An
Bord
Pleanála

Board Direction
BD-005239-20
ABP-305844-19

The submissions on this file and the Inspector's report were considered at a Board meeting held on 25/02/2020.

The Board decided to grant permission generally in accordance with the Inspector's recommendation, for the following reasons and considerations, and subject to the following conditions.

Drawing file: 305844 / 6384_306 Proposed Boundary Details - Entrance Design, Old Dublin Road (Preferred Option).pdf

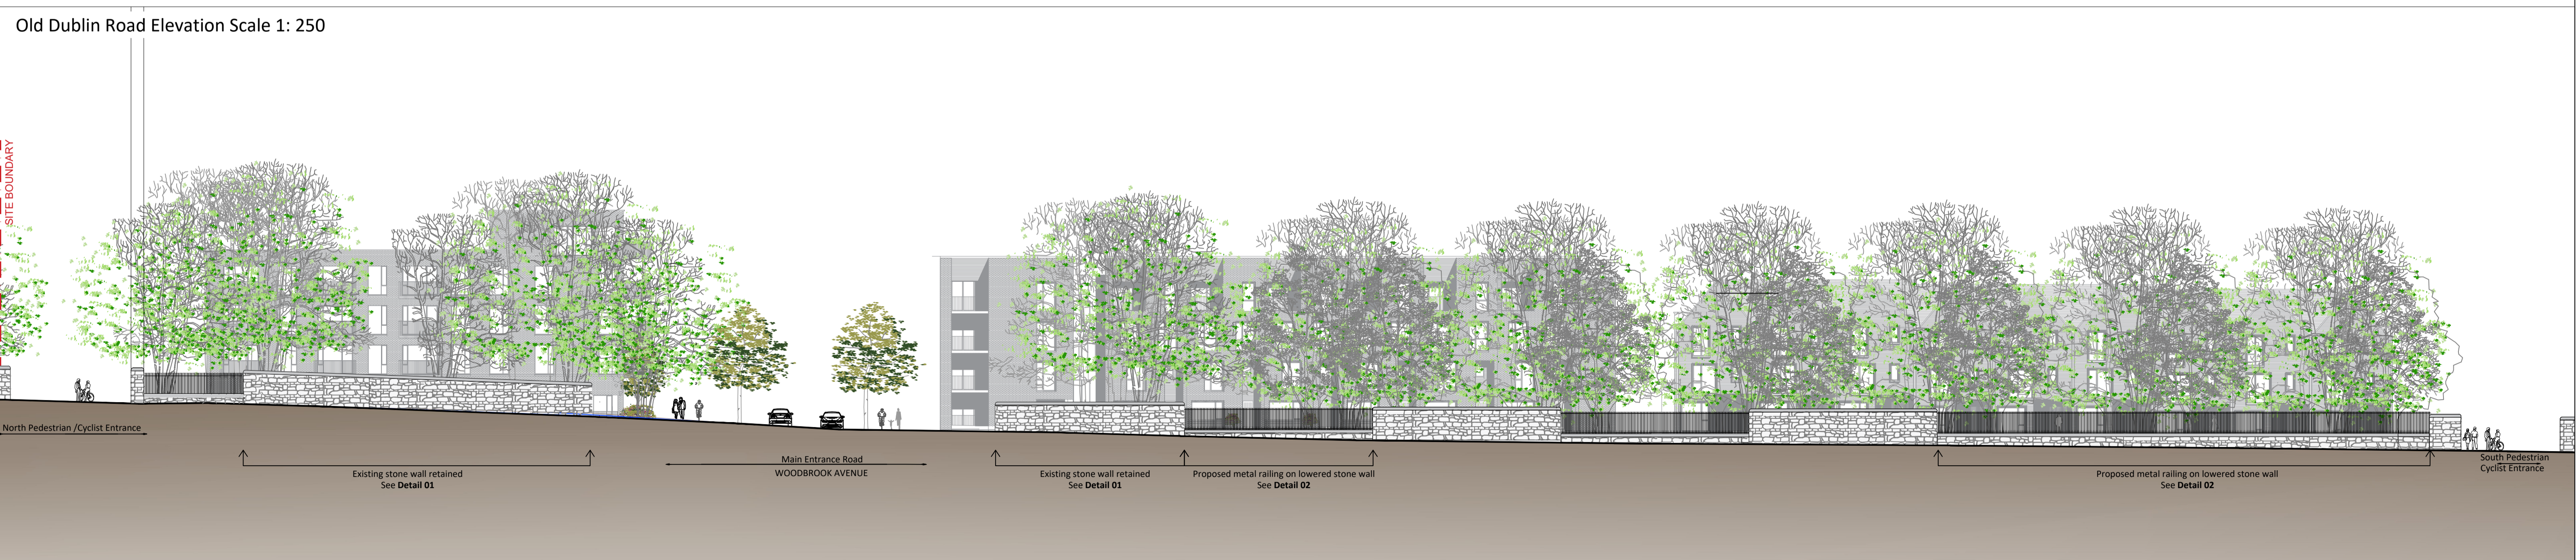
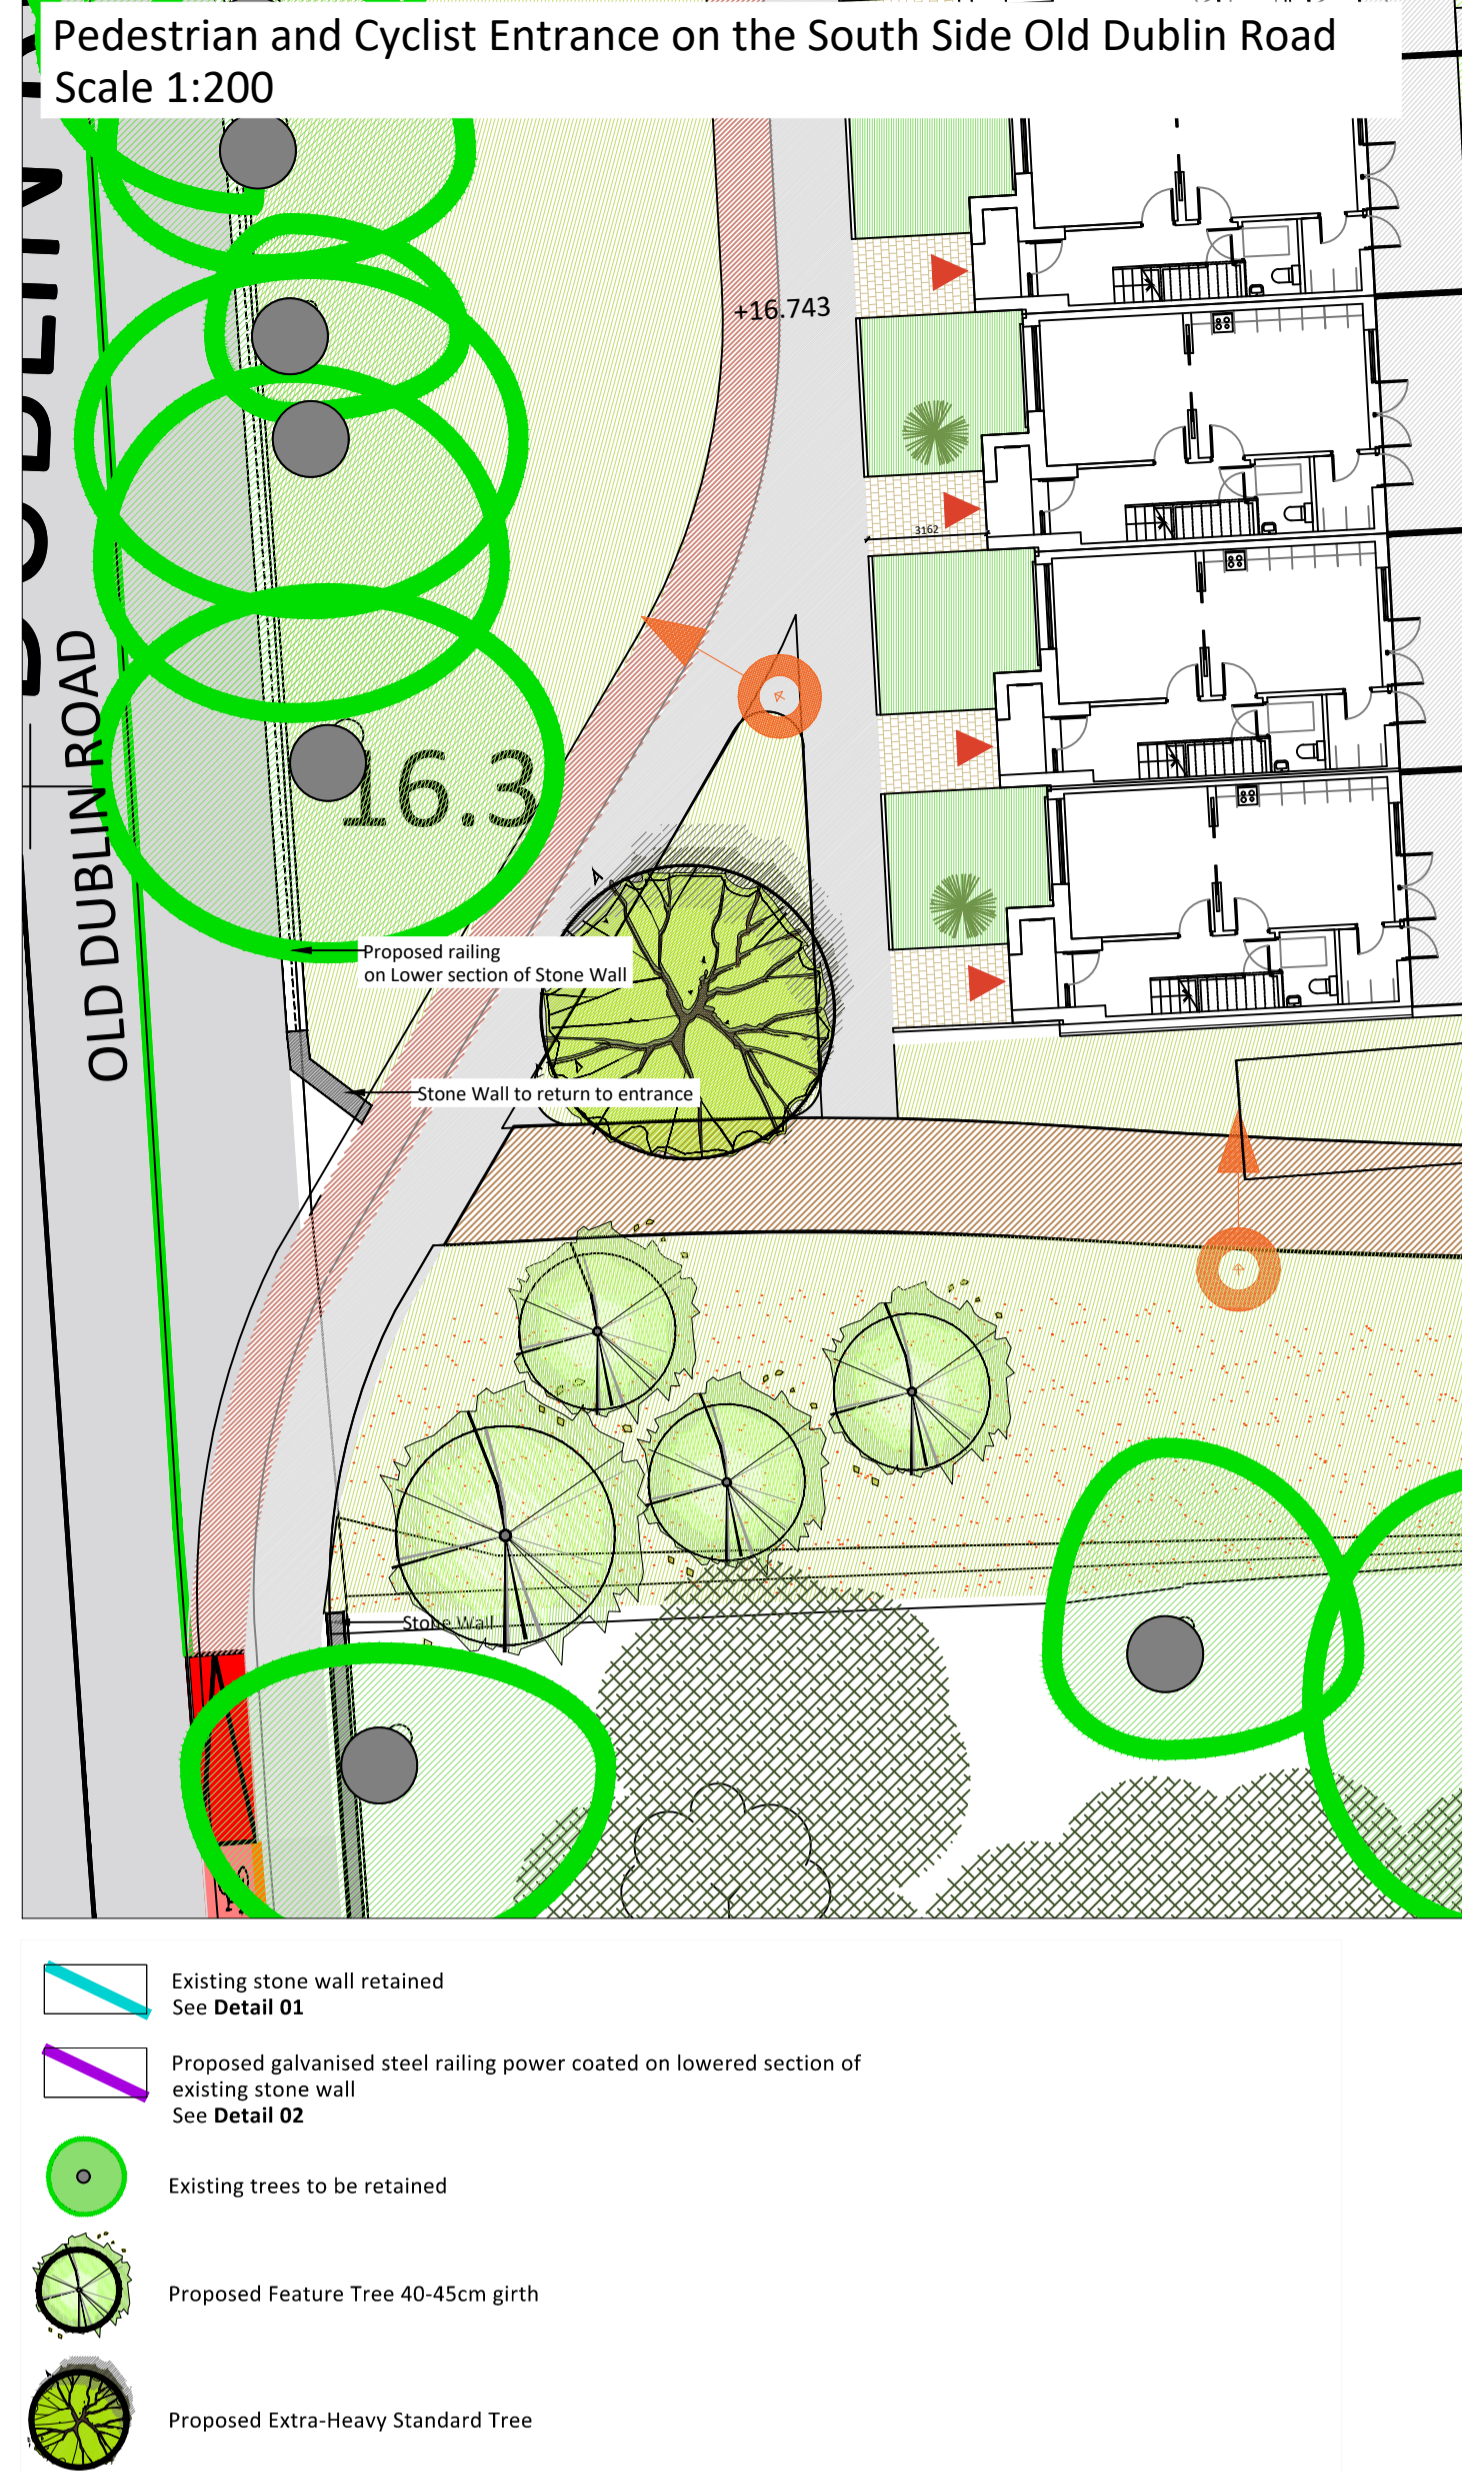
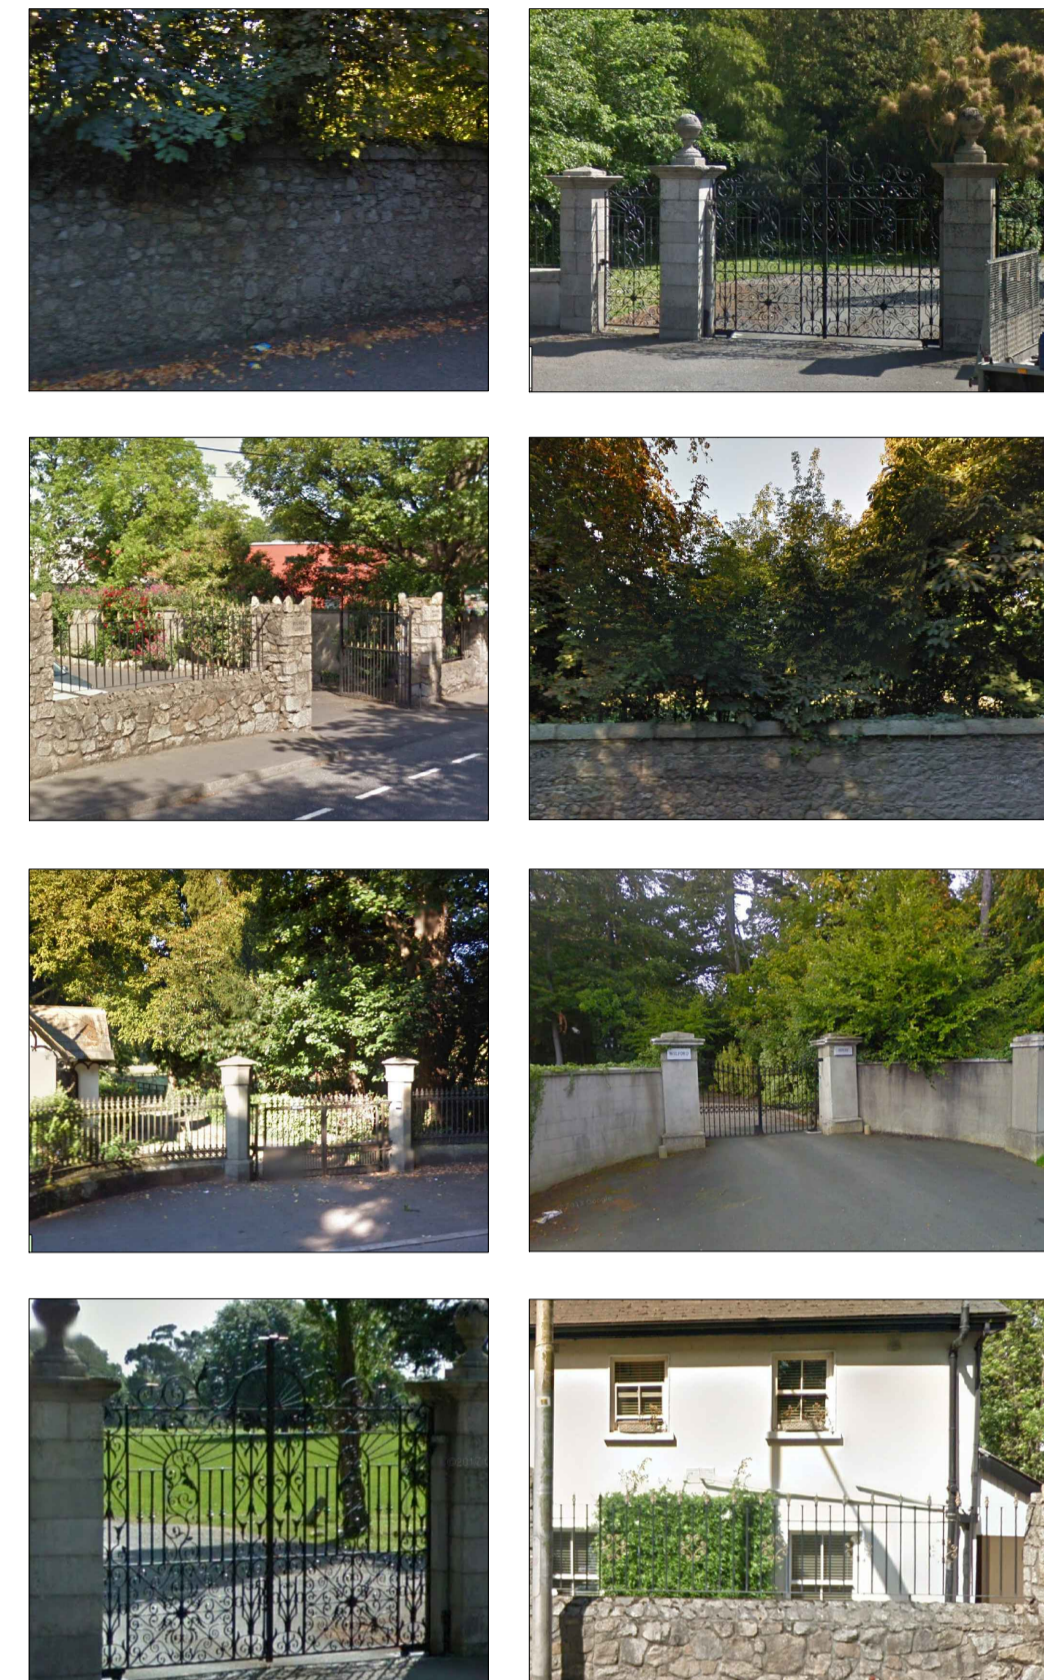
8. The proposed new road junction layout on the Old Dublin Road to serve the proposed development shall comprise of Option 1, as submitted with this application. Any future changes to the access road junction and boundary arrangements shall be the subject of a further planning application to the Local Authority.

Note: In deciding not to accept the Inspectors recommendation to proceed with the Road Junction Option 2, the Board was satisfied that Option 1 represented the optimal solution in terms of tree protection and cyclist and pedestrian safety and would be in accordance with the proper planning and sustainable development of the area.
